RE: METRO WEST STATION EIS – SSI 22765520 - NORTH STRATHFIELD STATION

Submission for the Metro West Station EIS – North Strathfield Station

Response to EIS and Station Design Principles

Figure 10-1 Indicative layout and key design elements – North Strathfield metro station

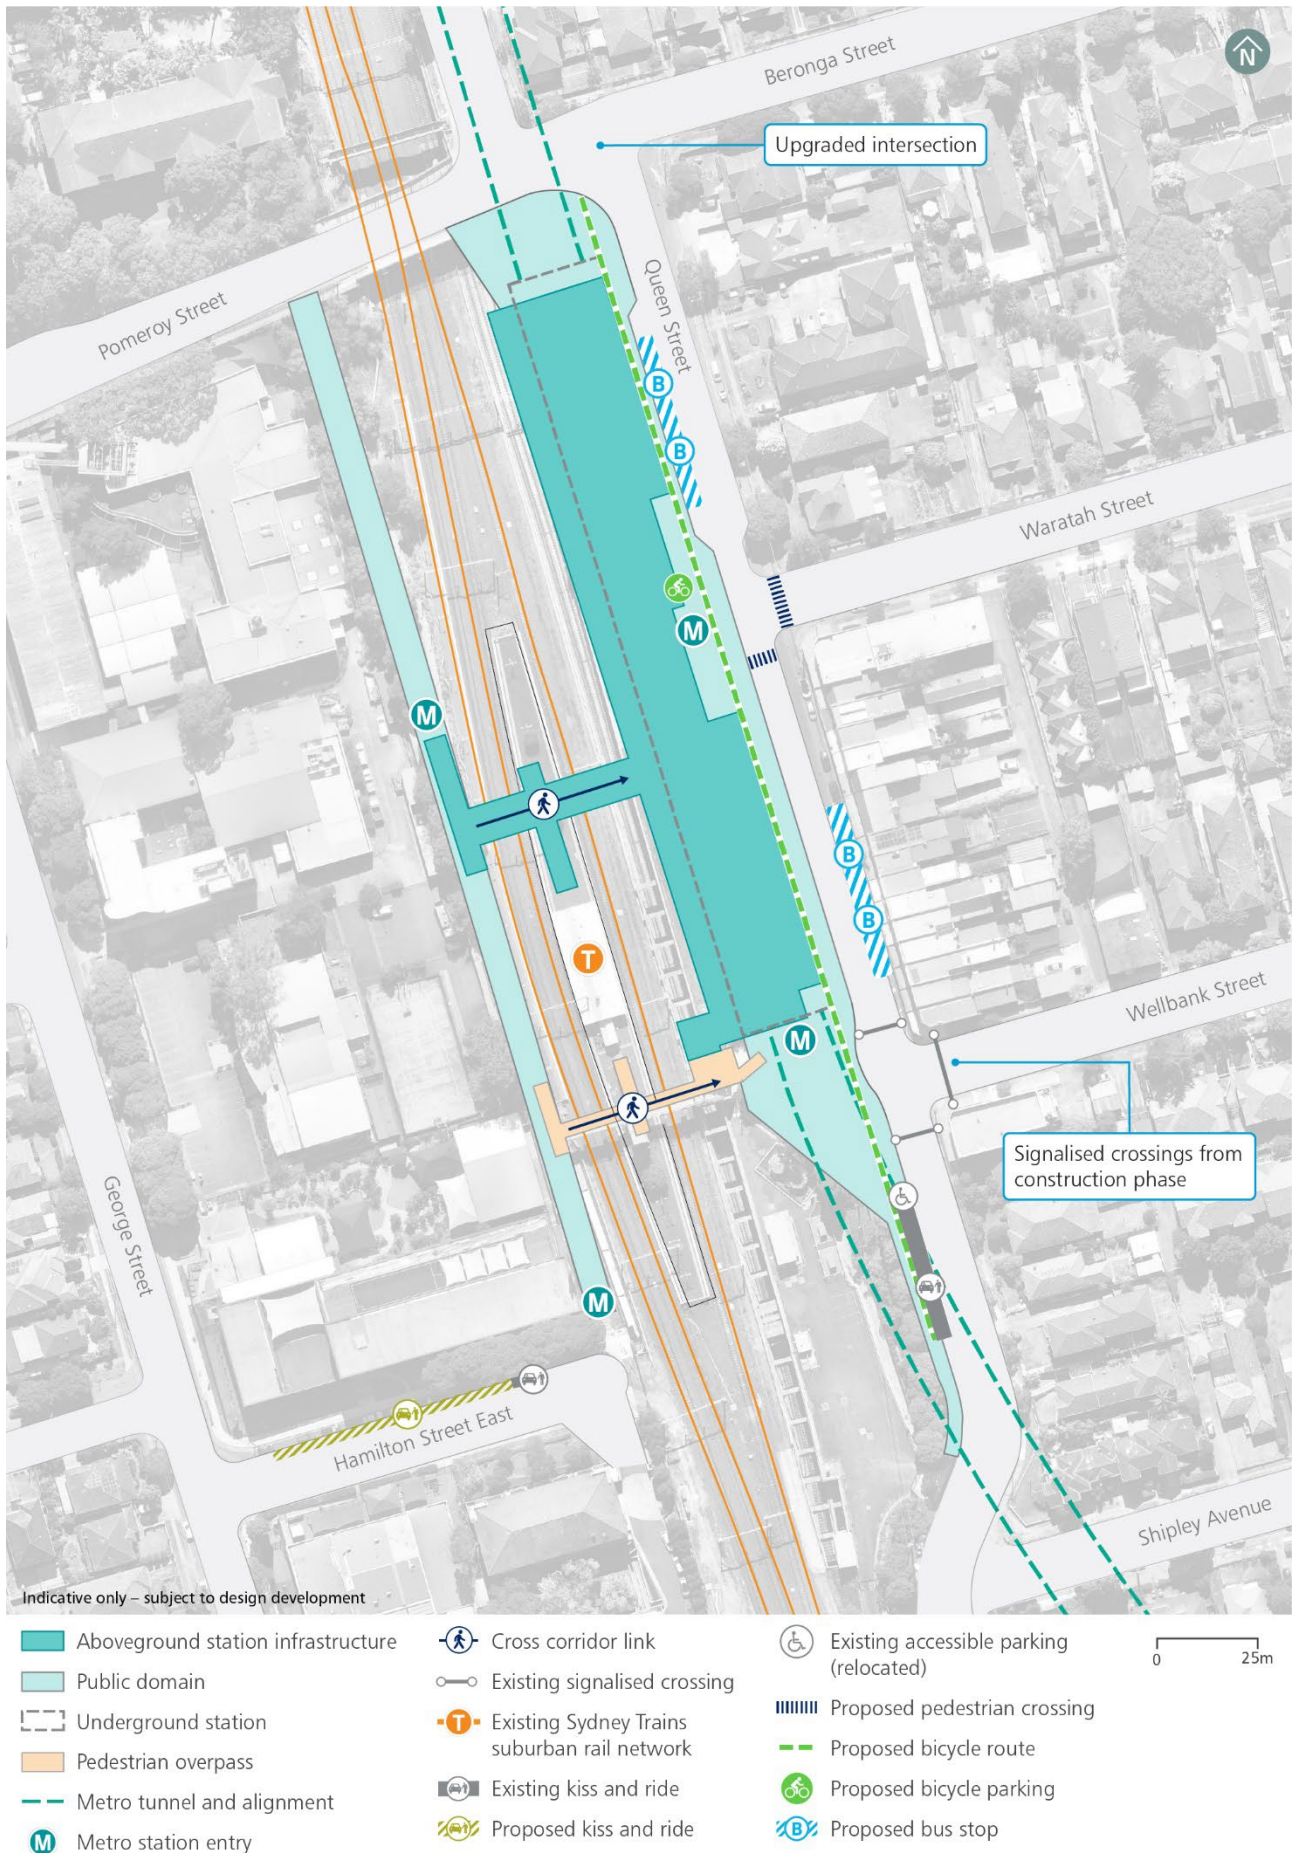
The access from the west delivers the antithesis of legible, safe and intuitive access. The distance to the new pedestrian bridge proposed (which appears to be the primary) is around 130m from either Pomeroy St or the dead end Hamilton St along a narrow path next to the heavy rail corridor. This pathway has no natural surveillance or

activation and it is difficult to see how it can deliver safe access that in anyway complies with the base principles of CPTED. Safety and CPTED principles are a core part of both the over arching Design Guidelines and the place specific design elements section within this document. The proposed station concept for North Strathfield is clearly deficient in this area.

It will be difficult to provide weather protection along the western access corridor and overhead pedestrian bridges. Basic overhead cover does not provide adequate protection for driving rain and enclosing the pathway entirely will cause heat build up during hotter months. Covered or enclosed walk ways also generally unsightly.

Interchange via an overhead pedestrian bridge provides a poor customer experience and the requirement for vertical travel at both ends will likely lead to bottlenecks during peak times. The Social Impacts report forming part of the EIS also raises the prospect that the proposed North Strathfield Metro Station will be a significant interchange location for transport users wanting to access Sydney Olympic Park for large events. The proposed overhead bridges with the requirement for vertical movement at both ends are likely to result in significant bottlenecks for patrons. The EIS does not adequately assess this issue or analyse the safety risks associated with crowd crush during these peak event times.

The aboveground station infrastructure (including new pedestrian footbridge, station services and space for non-station use) would rise about six to seven storeys above the street at the northern end of the station.

Massing and sections show lower height built form elsewhere in the EIS, typically only 3 storeys. There is also no detail provided on floor to floor heights or overall building height for the structure.
